Response to Submissions

For Development at Rathmorrissy, Pollnagroagh,
Moanbaun, Castlelambert, Knocknacreeva,
Caraunduff, Caherbriskaun, Lisheenkyle East,
Barrettspark, Cashla, Athenry, County Galway.

on behalf of Bord Gáis Energy Limited

Client	Bord Gáis Energy Limited	
Project Title	Cashla 220kV Substation and Grid Connection	
Document Title	Response to Submissions	
Document Comprises	Volumes	0
	Pages (Including Cover)	69
	Appendices	2
Prepared by	Muireann Carroll	
Checked by	PG	
Office of Issue	Dublin	
Document Information	Revision	0
	Status	Final
	Issue Date	August 2026

**Site Layout Plan**  
Scale : 1:500

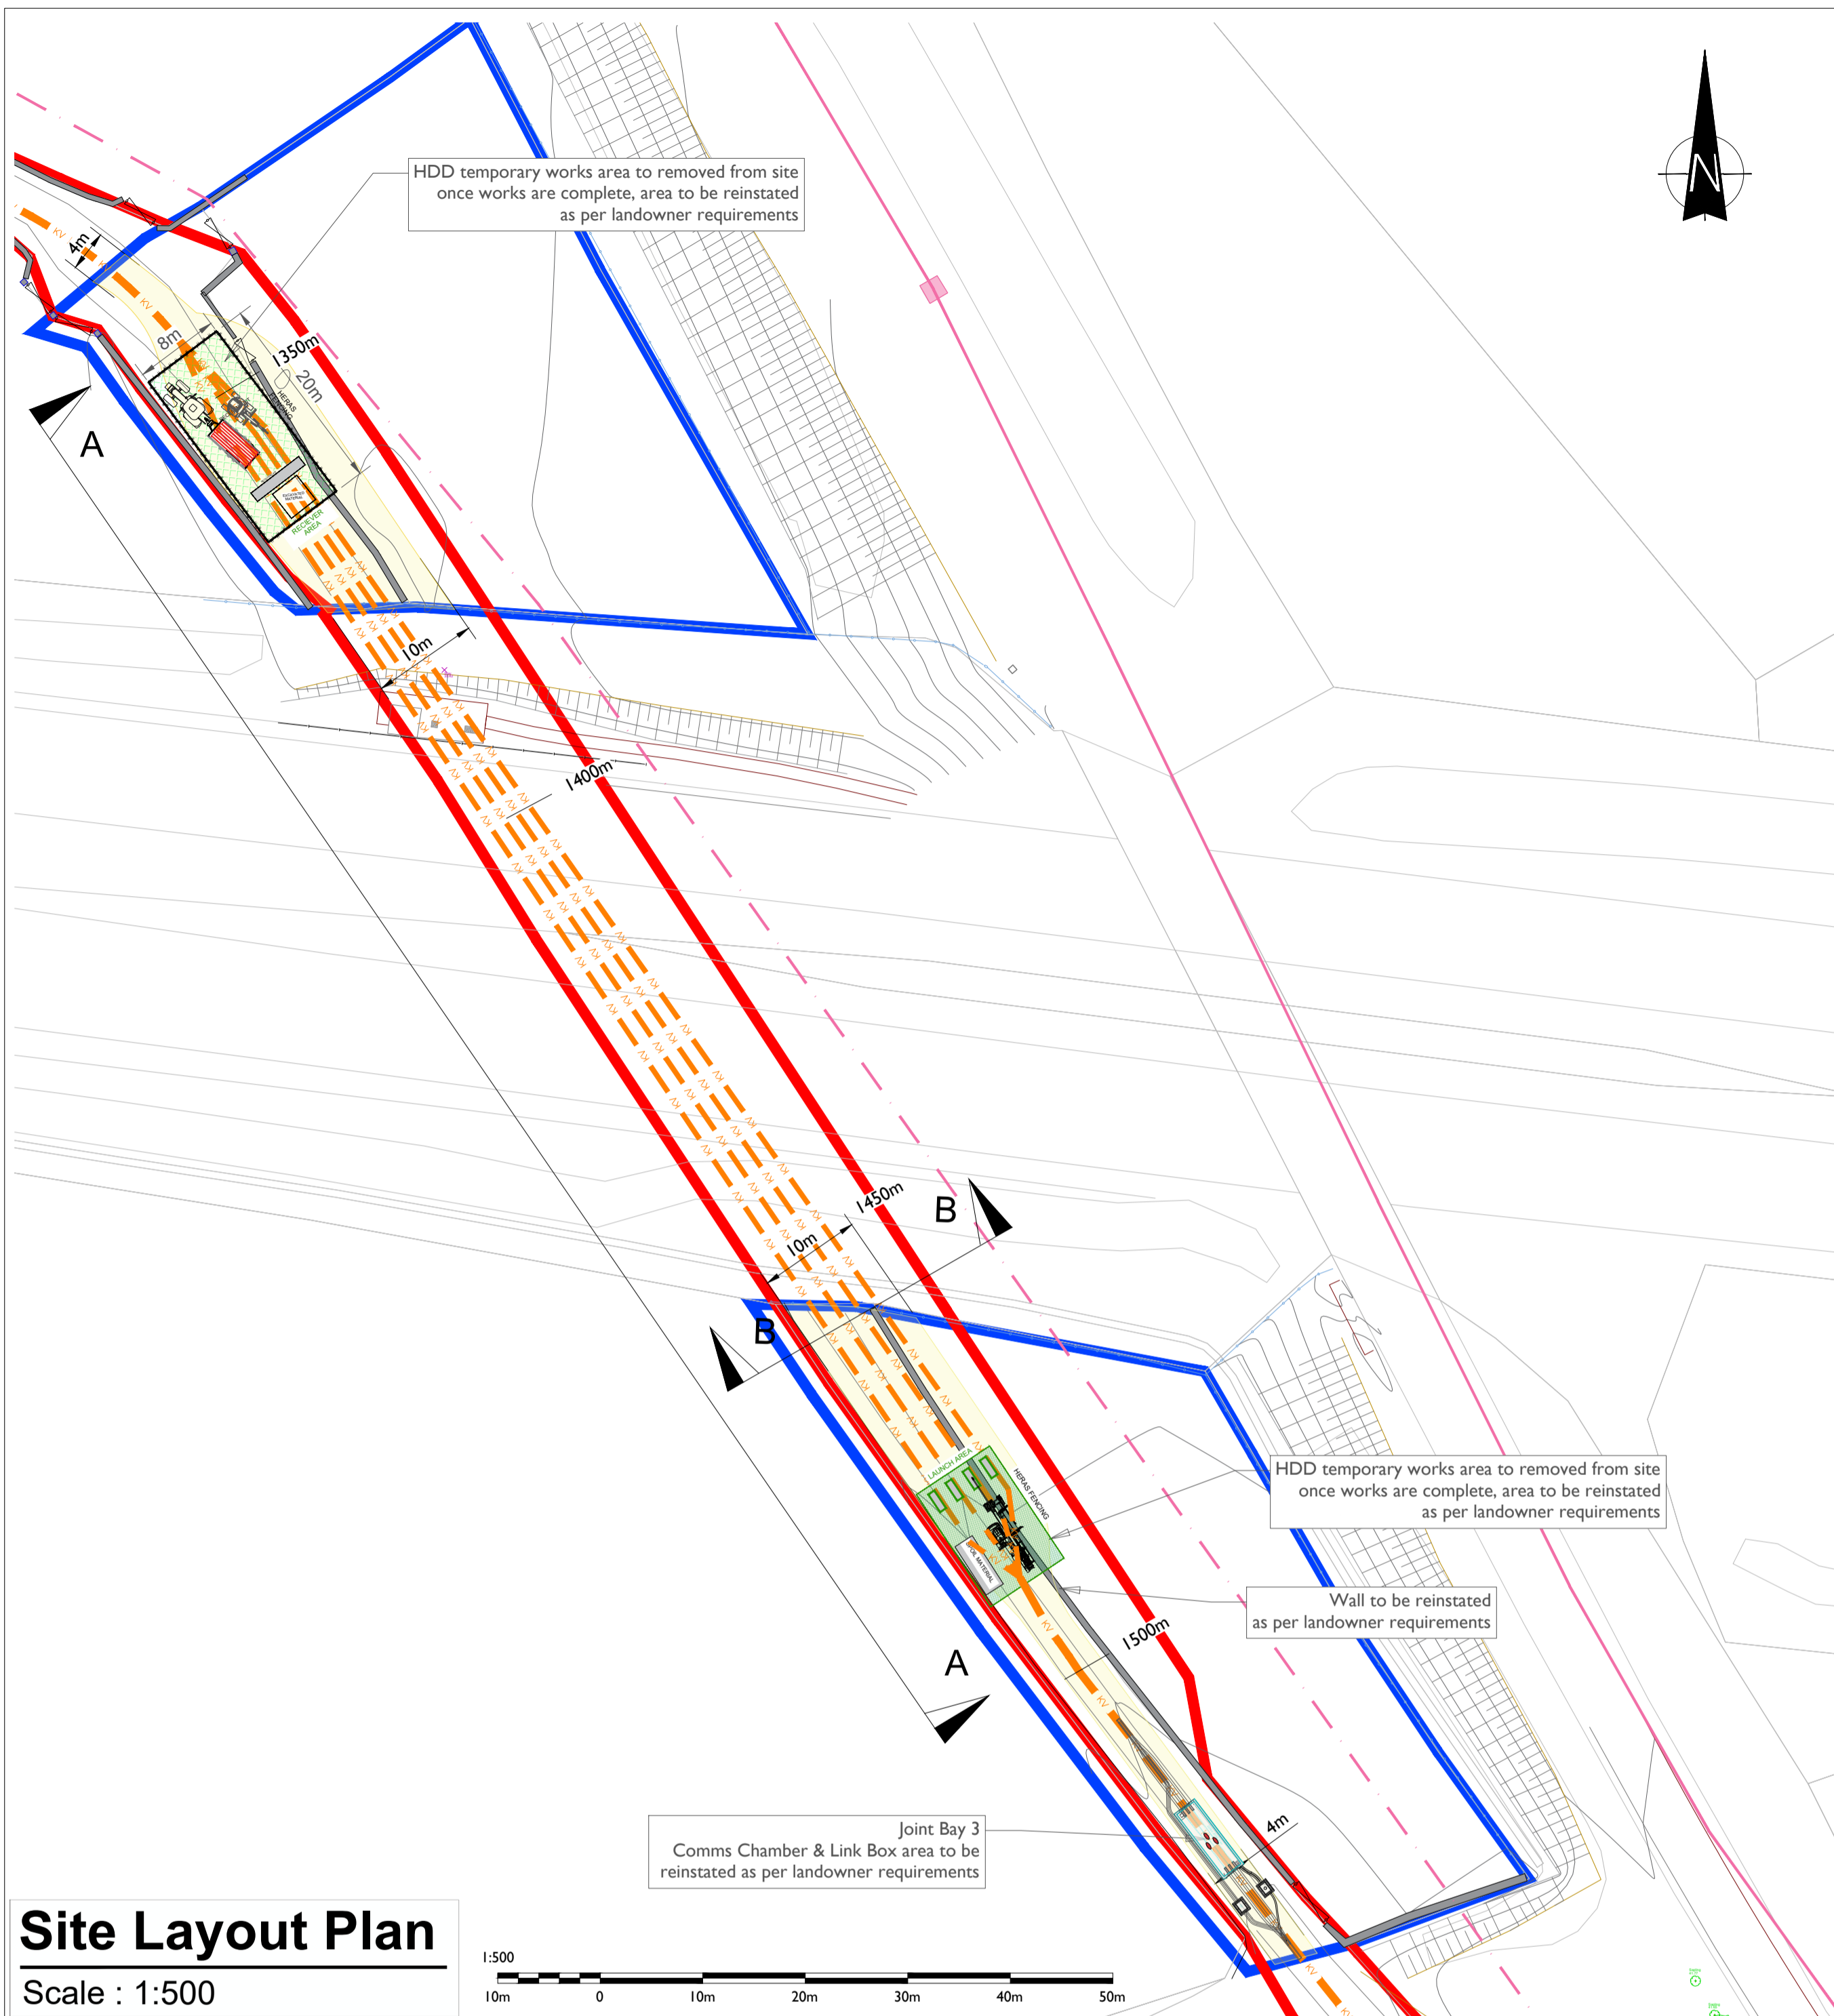
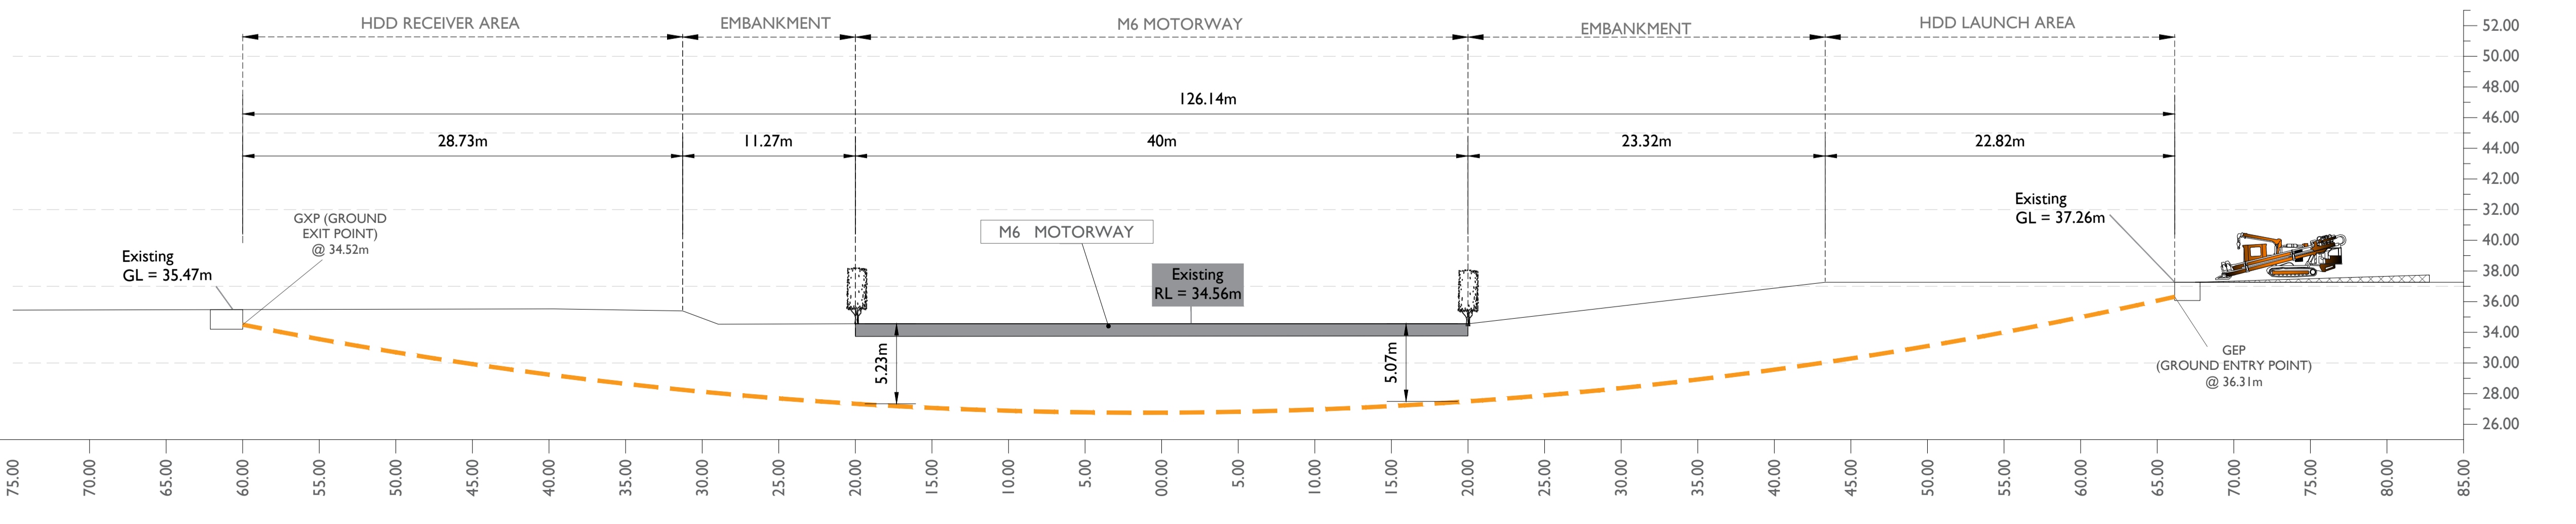
Galway County Council stated that a detailed structural survey would be required where directional drilling is proposed in proximity to motorway bridge structures.

Detailed confirmatory surveys of each TII Eirspan Bridge encountered will be carried out, executing Principal Inspection Task Orders which are issued by TII or the Local Authority, to inform the detailed design phase. These will be assessed by including inspections, assessment and report preparation of structures.

Risk assessment and Method statements will be conducted by an approved Department of Transport (DTTAS) Bridge Asset Management System (BAMS) Qualified Engineering Inspector.
